**KIRKLEES METROPOLITAN COUNCIL
INVESTMENT & REGENERATION SERVICE**

DELEGATED DECISION TO DETERMINE PLANNING APPLICATIONS

Reference No:	2024/62/93170/E
Site Address:	Woodville Nurseries, Northfield Lane, Highburton, Huddersfield, HD8 0QT
Description:	Erection of detached garage and ground works
Recommending Officer:	Edward Cheseldine

Officer Report

Drawn DRH
Date October 2024
Scales As shown @ A2
Drawing No. 2244 - 0704 - P01

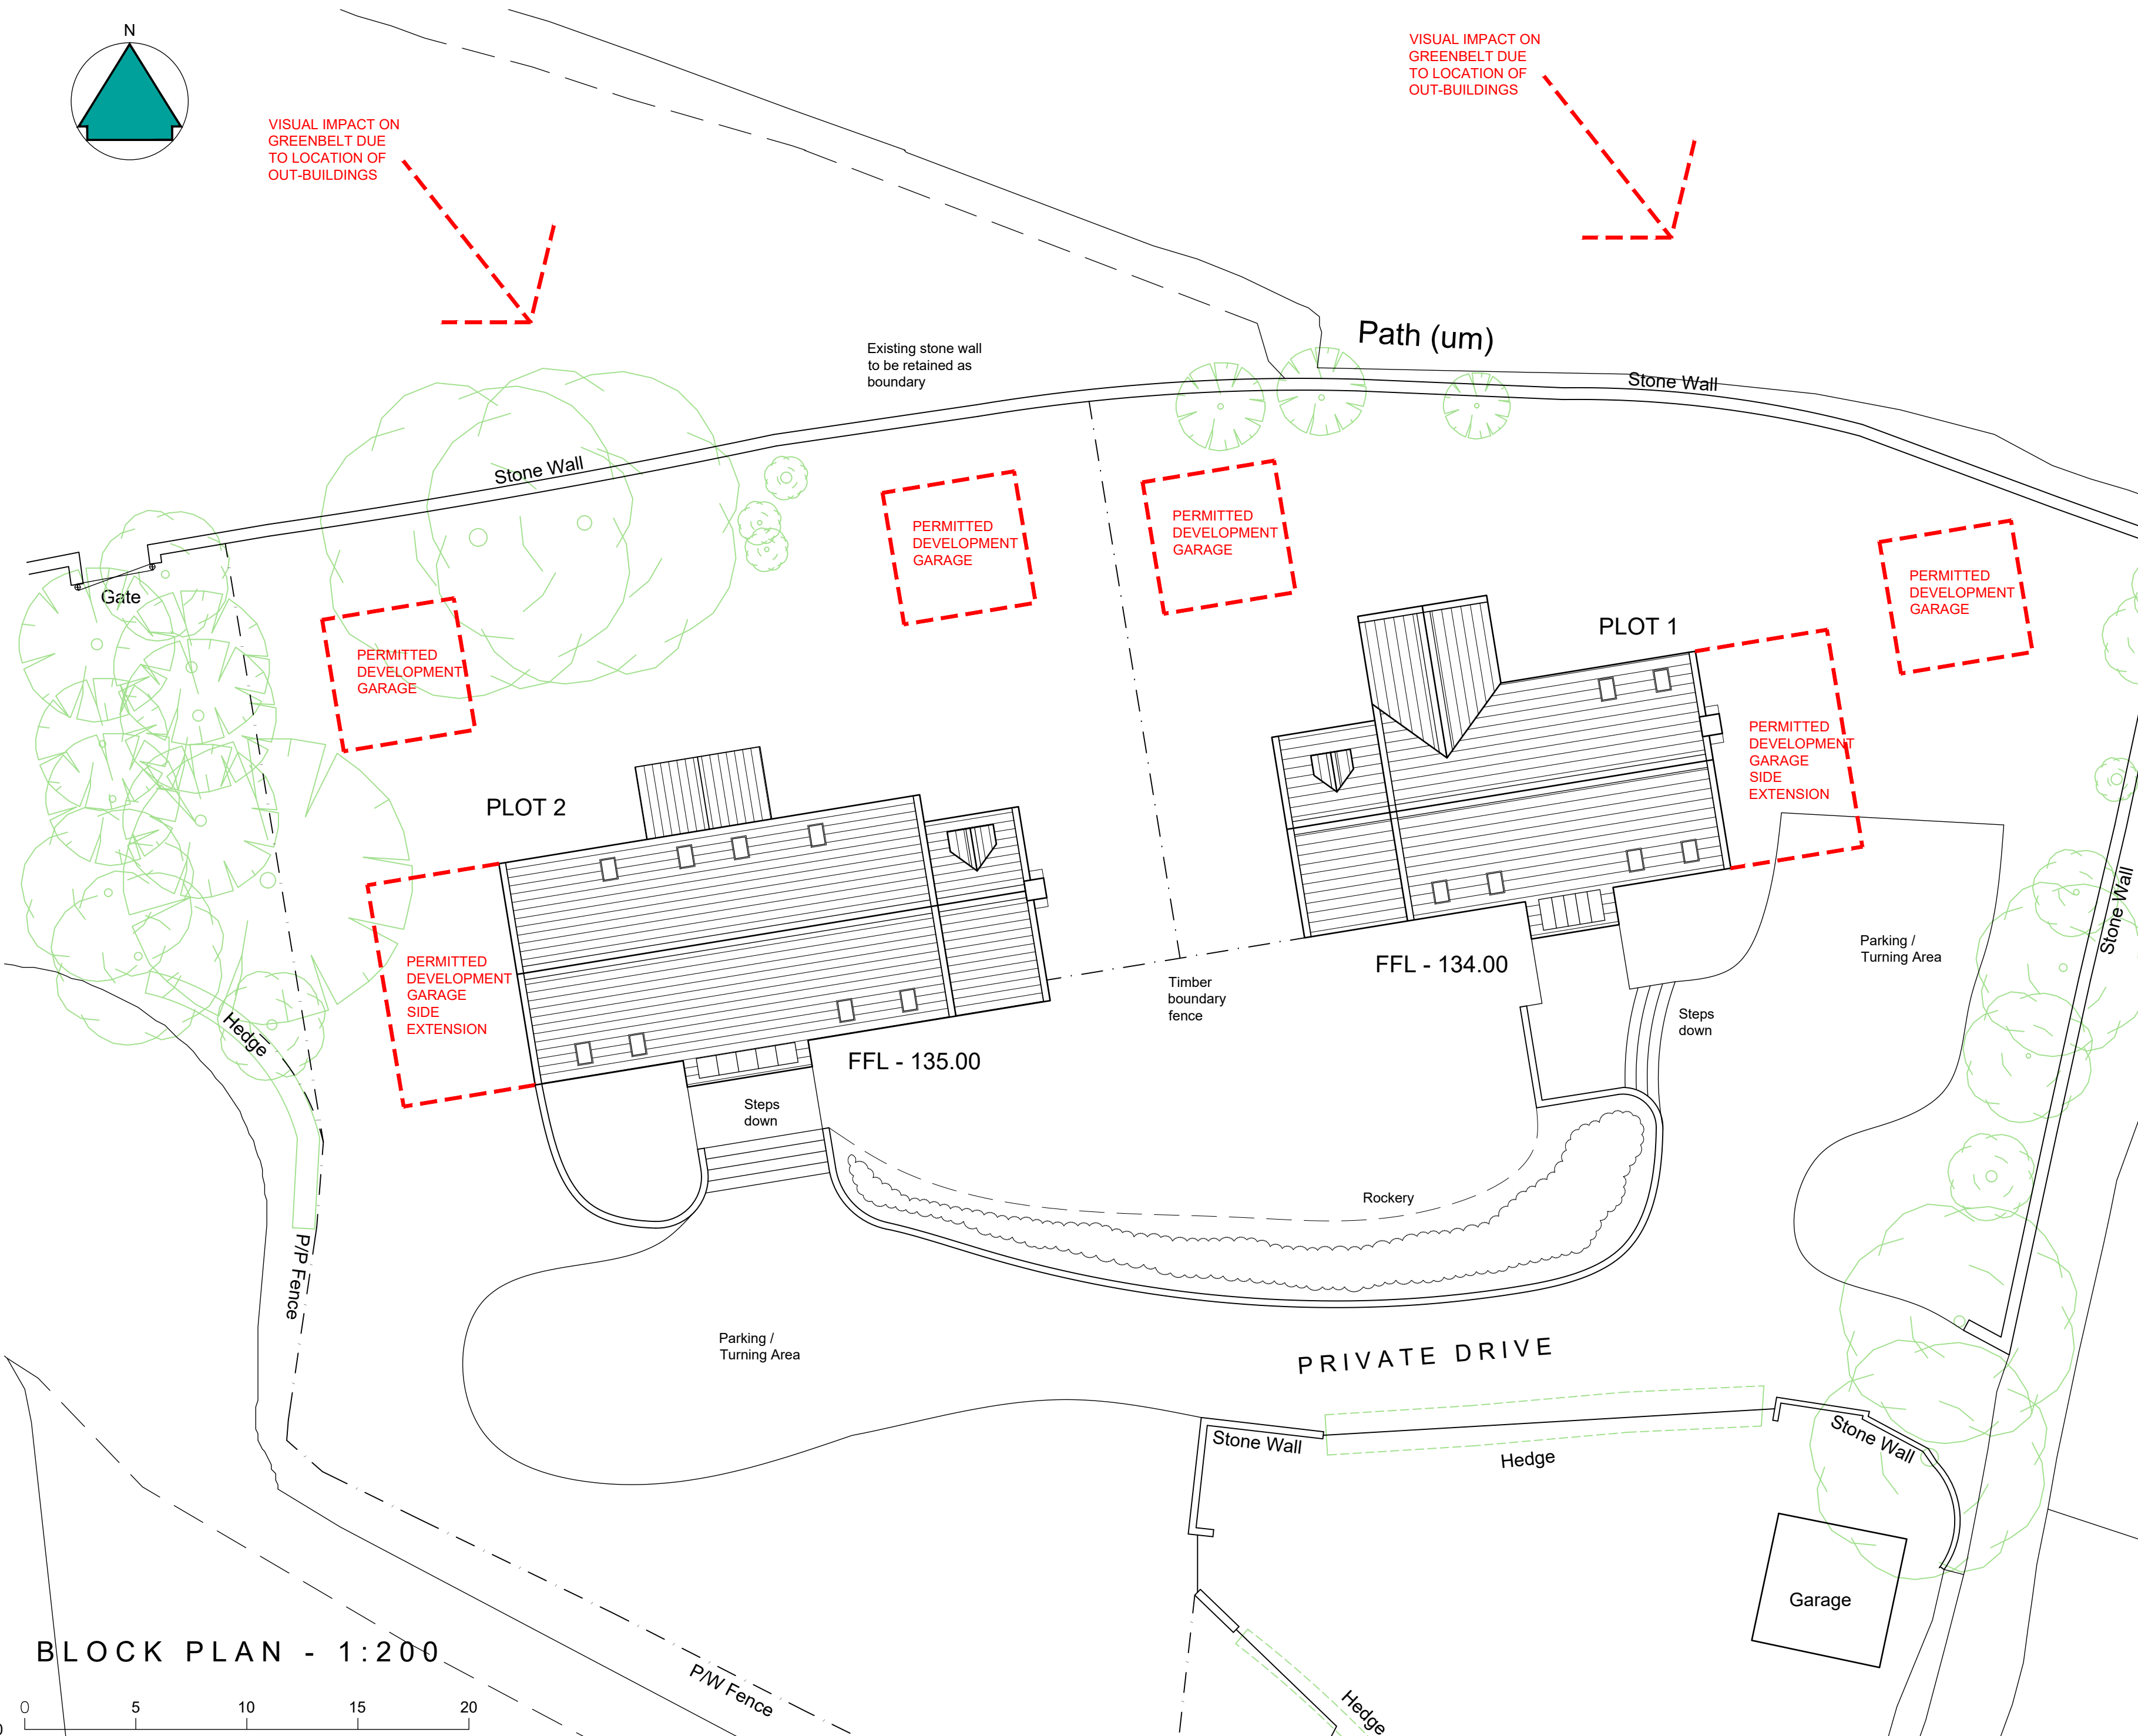
The applicant has submitted a 'Permitted Development Opportunities' plan. The dwellings were still under construction and have not been occupied therefore householder Permitted Development Rights do not currently apply to the site. The submitted documentation therefore holds minimal weight within the planning balance and will be assessed based on national and local planning policy.

The applicant has submitted a 'Permitted Development Opportunities' plan indicated their intention to seek extensions to the main dwelling. The accumulation of buildings would have an impact to openness which would conflict with the open character of the site and therefore the cluster of houses within the Green Belt. Due to the impact to openness which is one of the characteristics of the Green Belt, Permitted Development Rights Class A, B, D & E will be removed from the site to avoid overdevelopment and further greater impact on the openness and character of the area.

4. Notwithstanding the provisions of section 55(2)(a)(ii) of the Town and Country Planning Act 1990 and the Town and Country Planning (General Permitted Development) (England) Order 2015 (or any order revoking or re-enacting that Act or Order with or without modification) no extensions, roof extensions, porches or outbuildings (Class A, B, D & E), other than those expressly authorised by this permission shall be constructed on the site.

PLOT 1 - GARAGE FLOOR PLAN
1:100

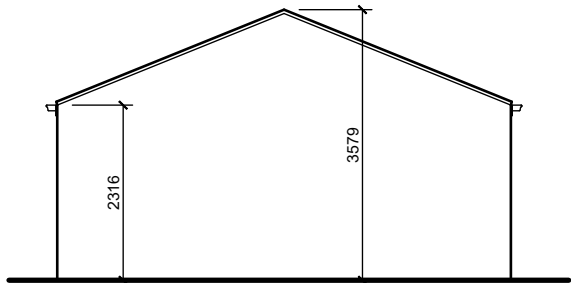
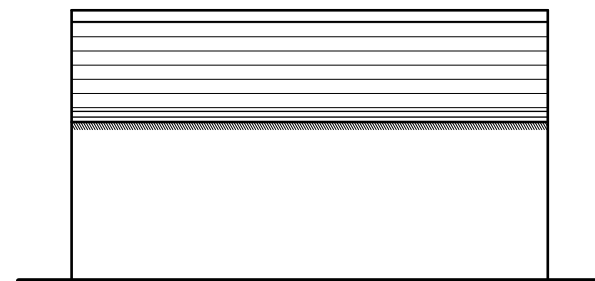
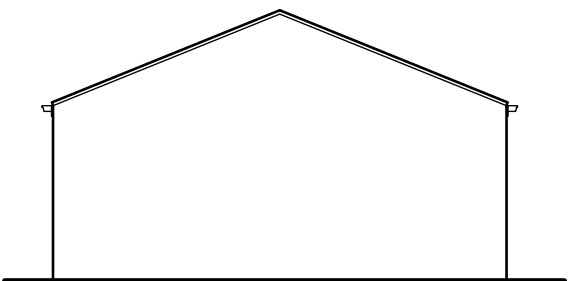
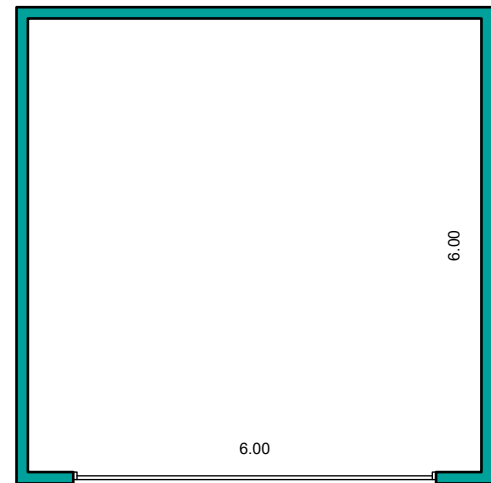
The applicant is seeking planning permission for the erection of a double, detached garage. The garage will be ~6.00m(w) x ~6.00(l), with an eaves height of 2.31m and a ridgeline height of 3.57m. The building will have a pitched roof. The exterior walls will be formed with tumbled and dyed stone, the roof will be clad with natural stone slates to match the existing structure. The garage will be positioned to the east of the dwelling.

The development is for a garage which will be 70.56m³. It is located to the side of the existing dwelling. A significant proportion of the footprint of the building is currently a hardstanding material. There will be a 8.68m gap between the side elevation of the garage and the boundary to the east. Side elevation plans indicate the scale of the garage is appropriate in consideration of the size of the dwelling. Materials are complimentary to the host building. The original dwelling will therefore remain the dominant element. Considering there is sufficient space between the garage and host dwelling, the open Green Belt character will not be harmed.

The outbuilding is not classed as a habitable room, there are no windows on the building, therefore there will be no impact to residential amenity.

3. The external walls and roofing materials of the outbuilding hereby approved shall in all respects match those used in the construction of the existing building.

BLOCK PLAN - 1:500

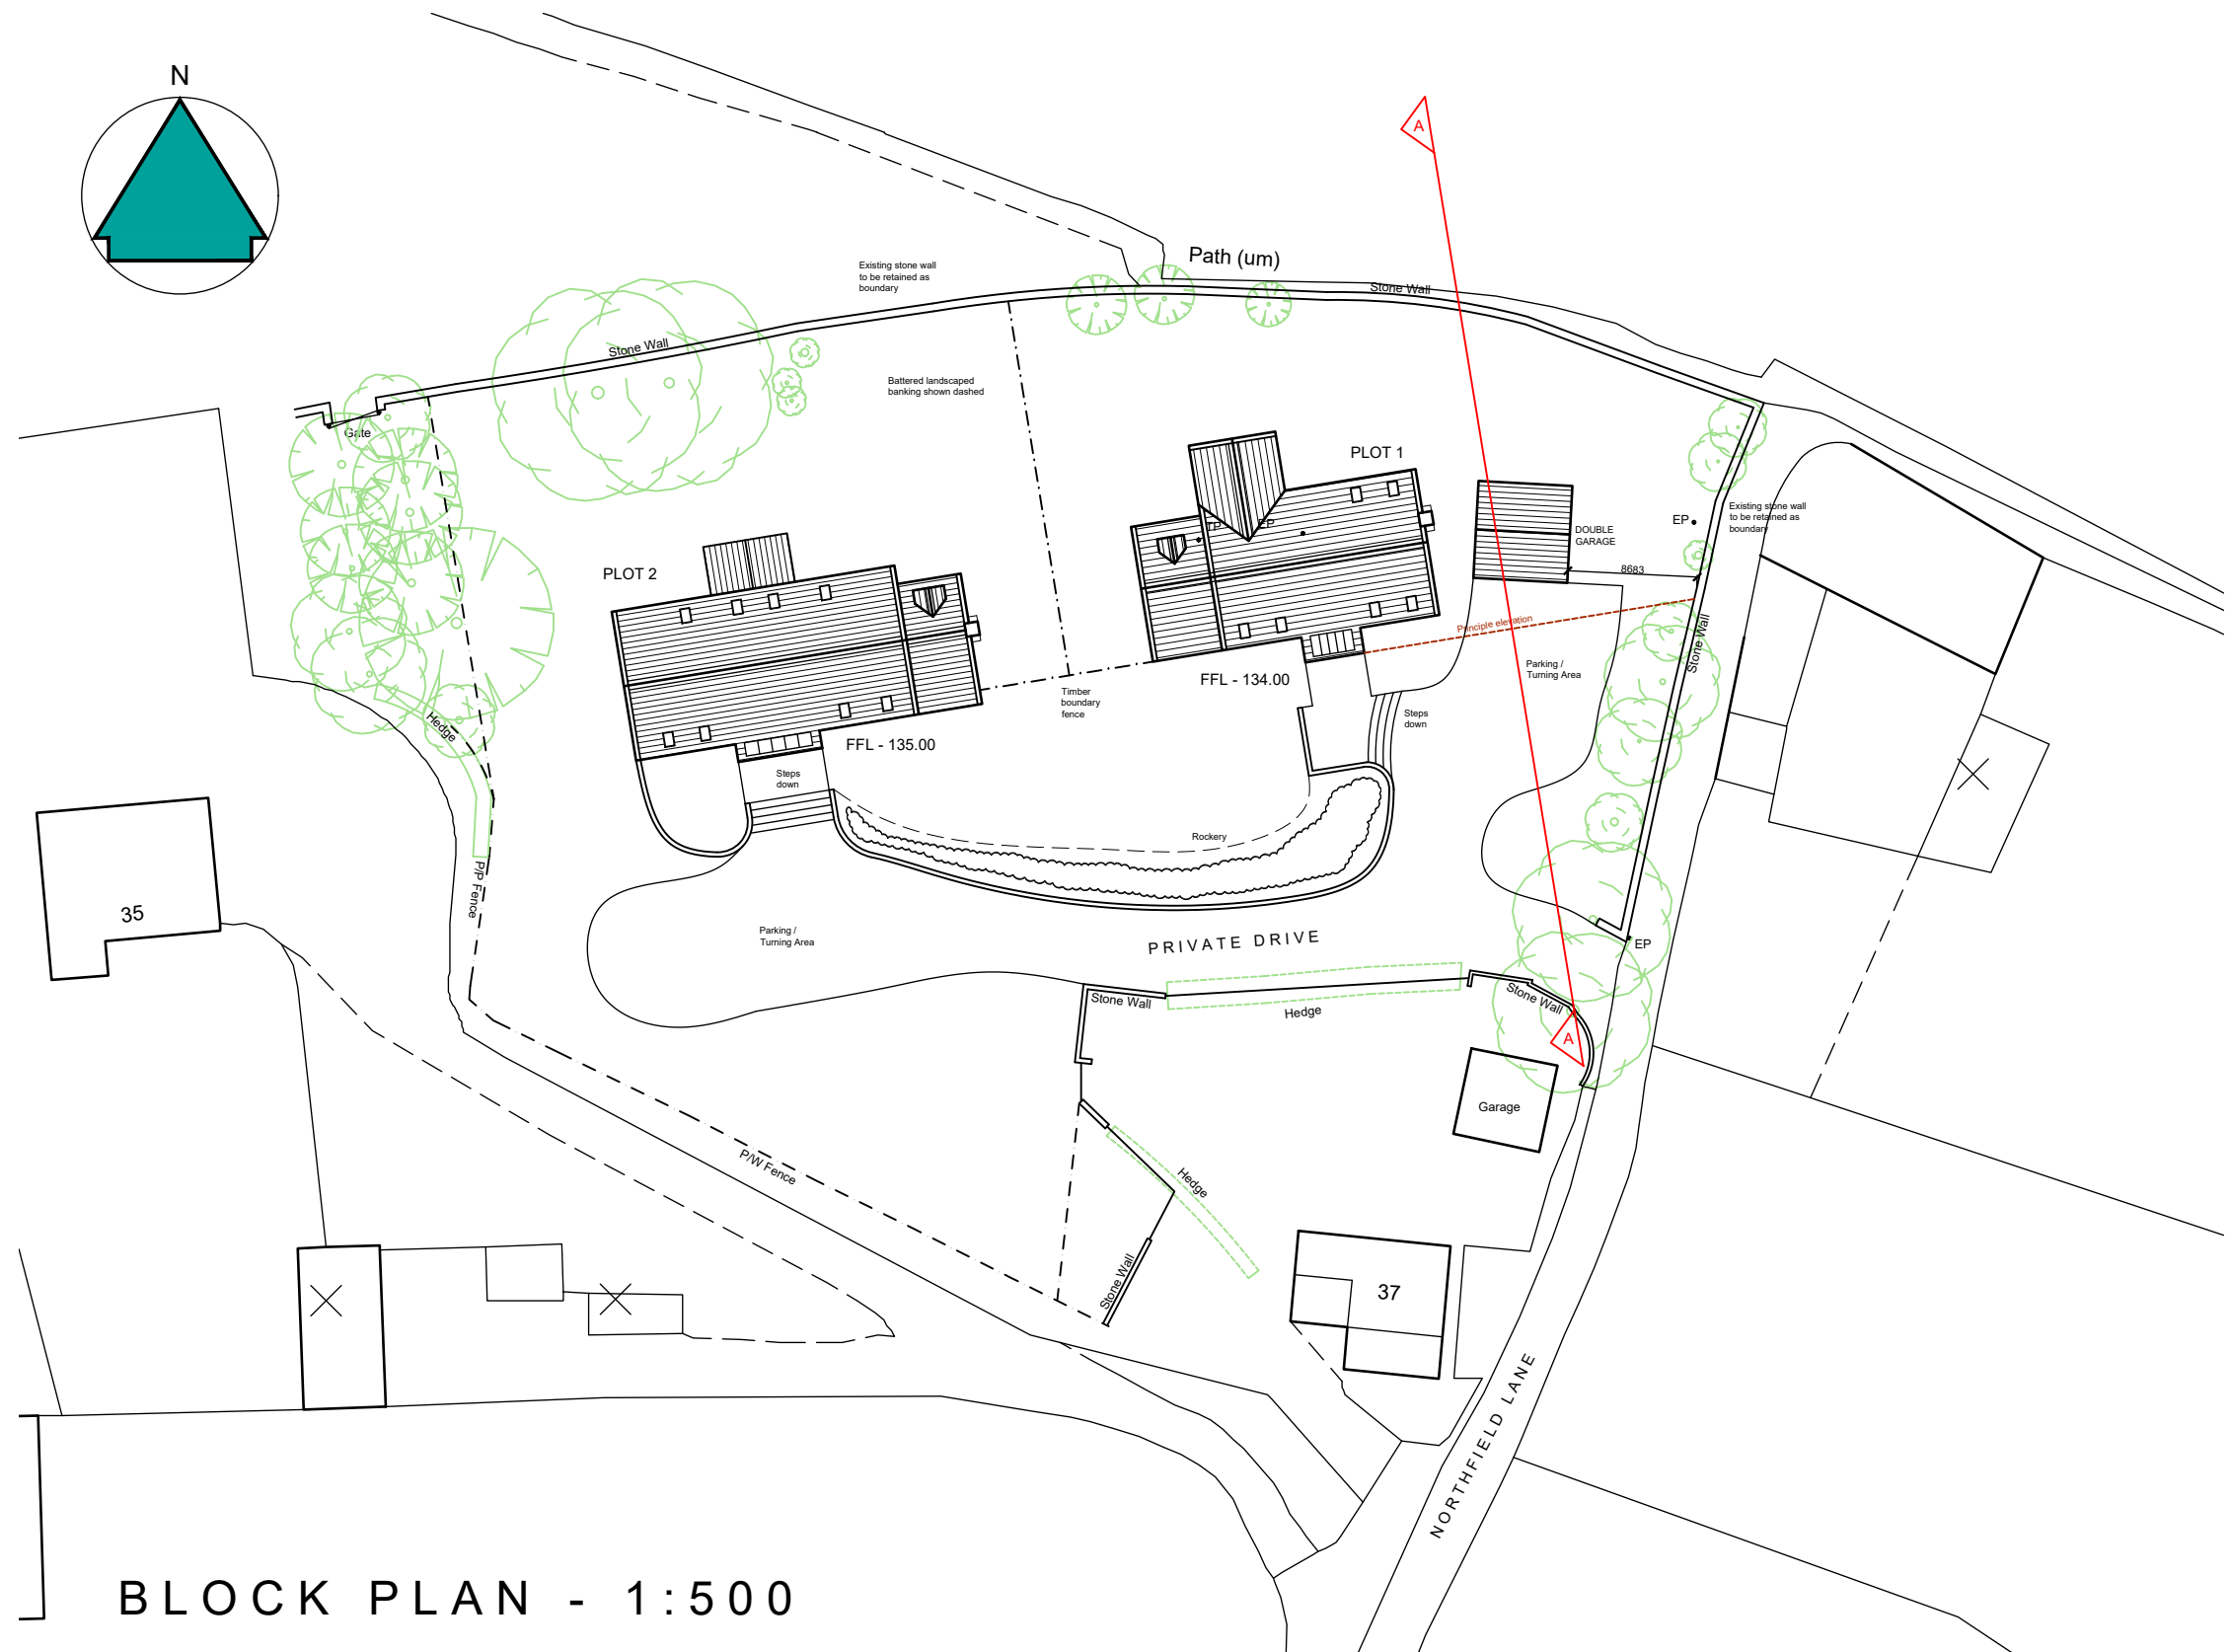
In terms of footprint and scale, to the original building and garden, the garage is an appropriate size and is acceptable in terms of Green Belt policy and LP24. The garage is set back from the main dwelling by ~4.70m. In term of garden space, the occupants will have access to a suitable amount of private outdoor space.

A small section (~2.50m in width) of hardstanding will be removed. The parking area/turning head will still be ~8.00m wide. The alterations will not impede the ability for cars to turn or reduce the number of parking spaces to what is considered unacceptable for the size of the dwelling.

PROPOSED SECTION A-A
1:200

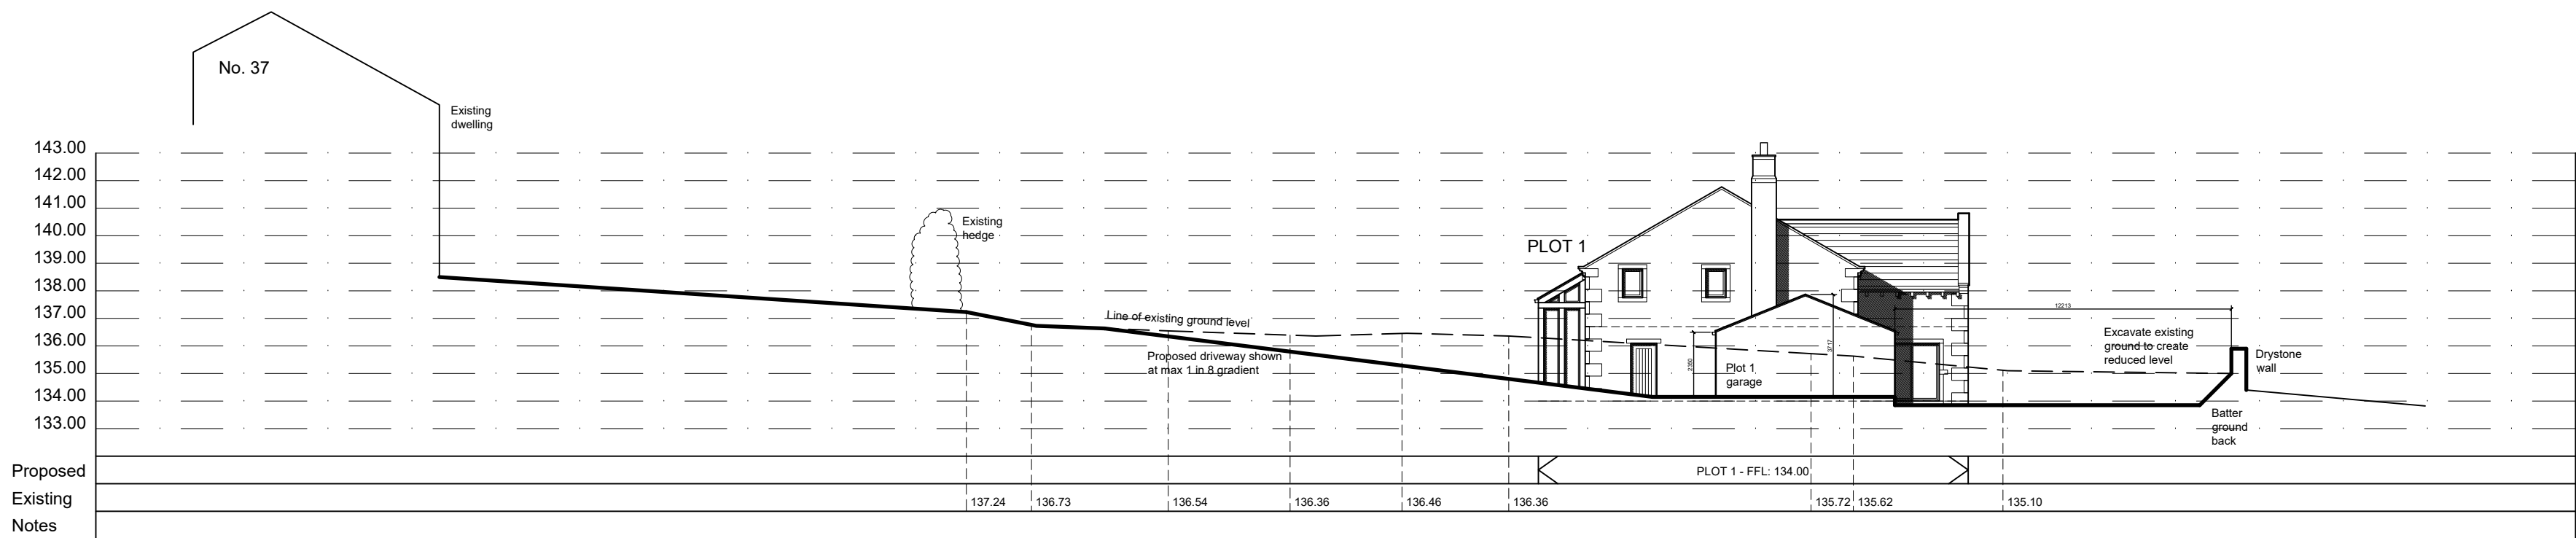
In addition, there will be earthworks to the rear section of the plot as the garden is sunk below the ground height of the garage. A section of the driveway will be removed and replaced with a grassed area. For the purposes of the Green Belt, the alterations will have no impact to the purposes of the land and are acceptable.
